**Dunedoo Solar Farm (SSD 8847)
Request for Additional Information**

I refer to the Department's assessment of the Dunedoo Solar Farm (SSD-8847). After careful consideration, the Department is requesting that you provide additional information addressing the items detailed below:

Figure 2-1 Dunedoo Solar Farm Topographical Map

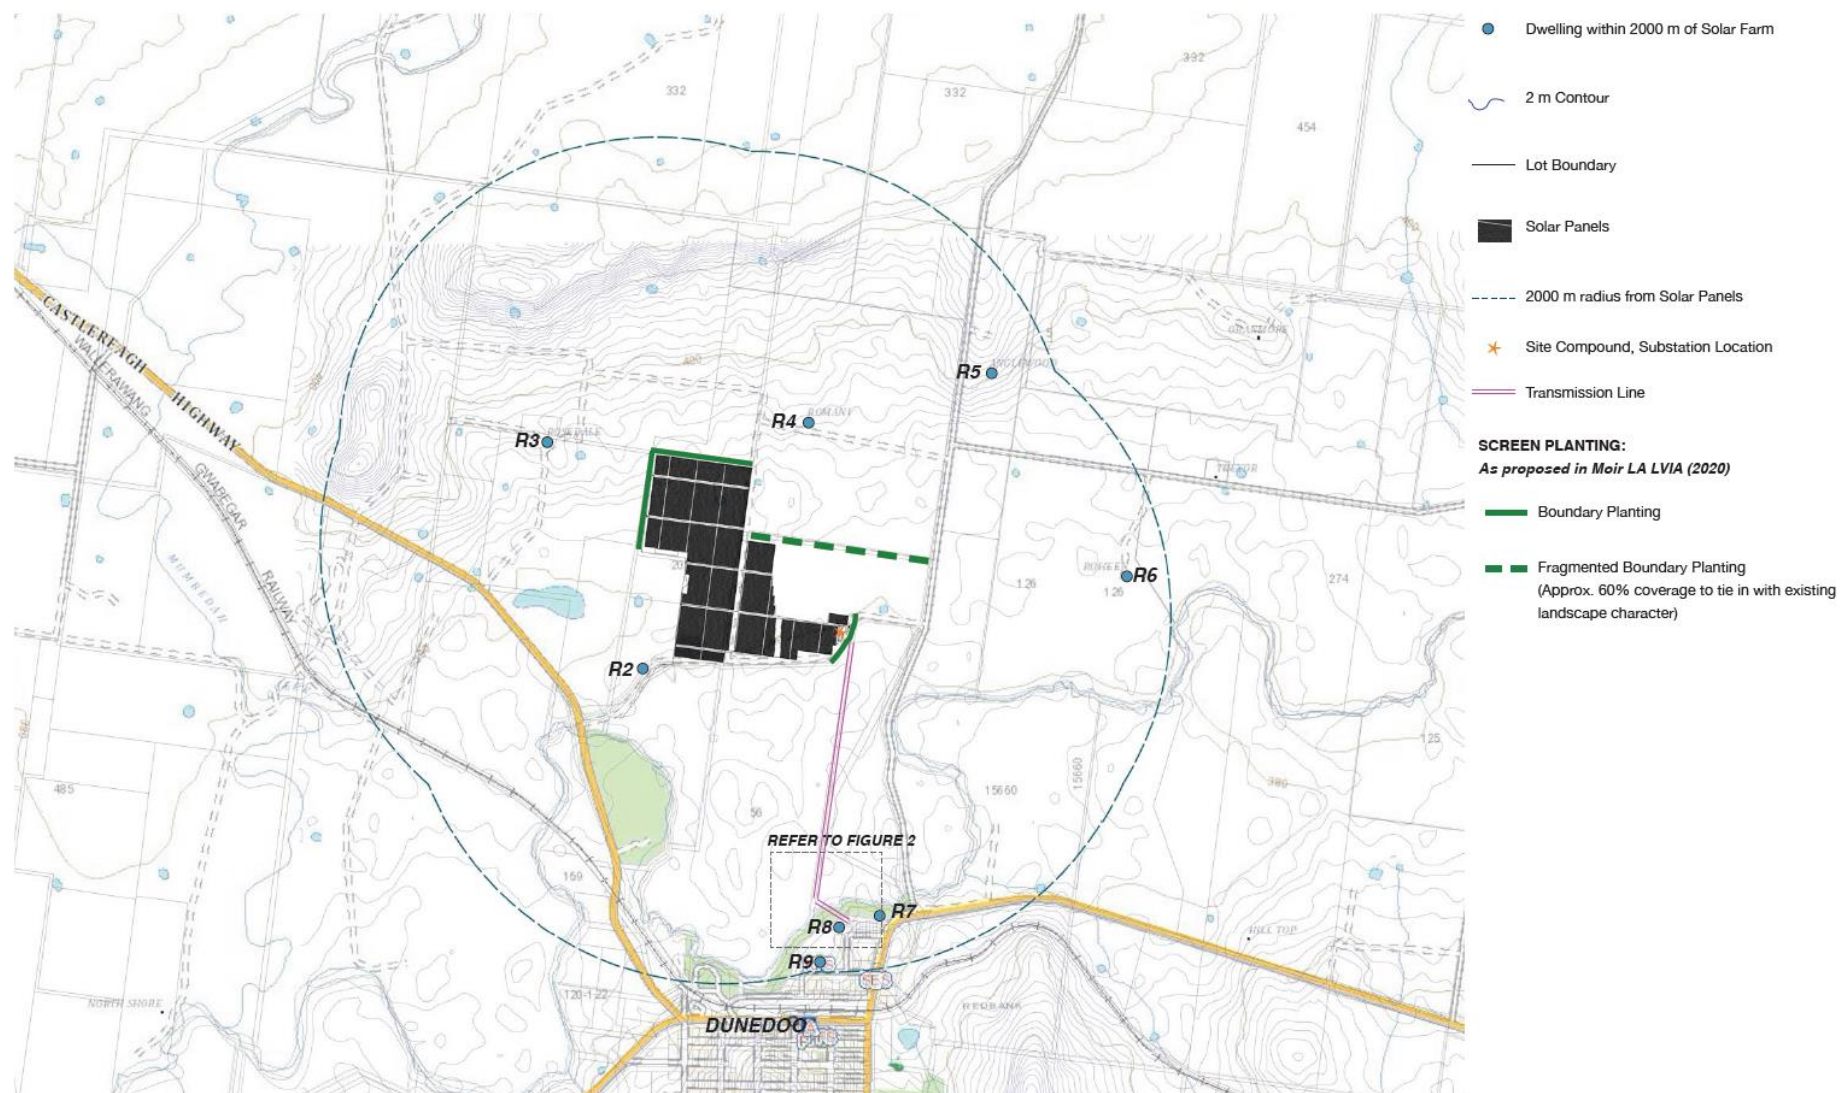
- topographical maps of the site and surrounding area for a 2 km radius; and
 - details of the proposed measures to mitigate the potential impacts on receivers.

Figure 2-2 Proposed and existing elements of Dunedoo Solar Farm

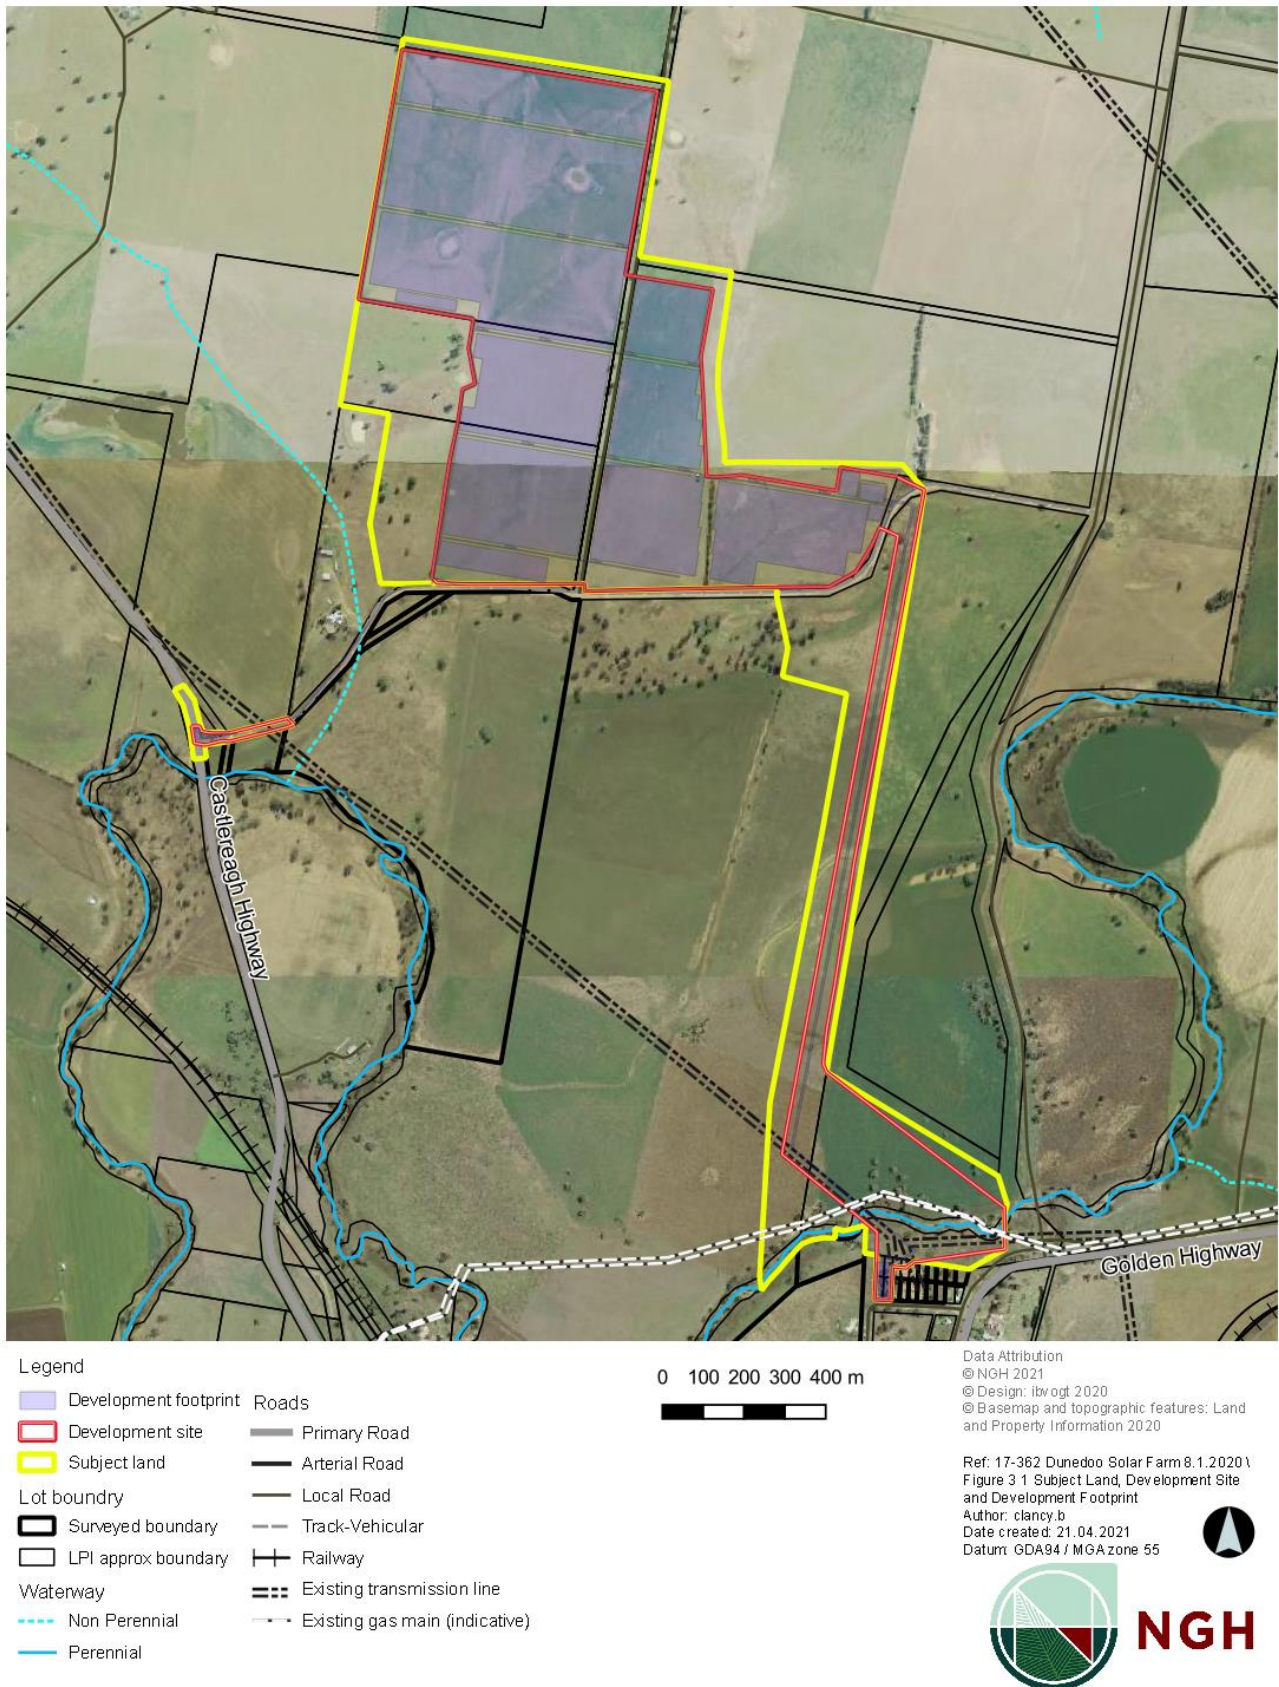
- Access: provide details of the site access points proposed for the transmission lines.
- Hazards: include the location of gas pipeline operated by the APA Group in the site layout plan, with this pipeline labelled as *'high pressure gas transmission pipeline – no works without prior approval of APA.'*
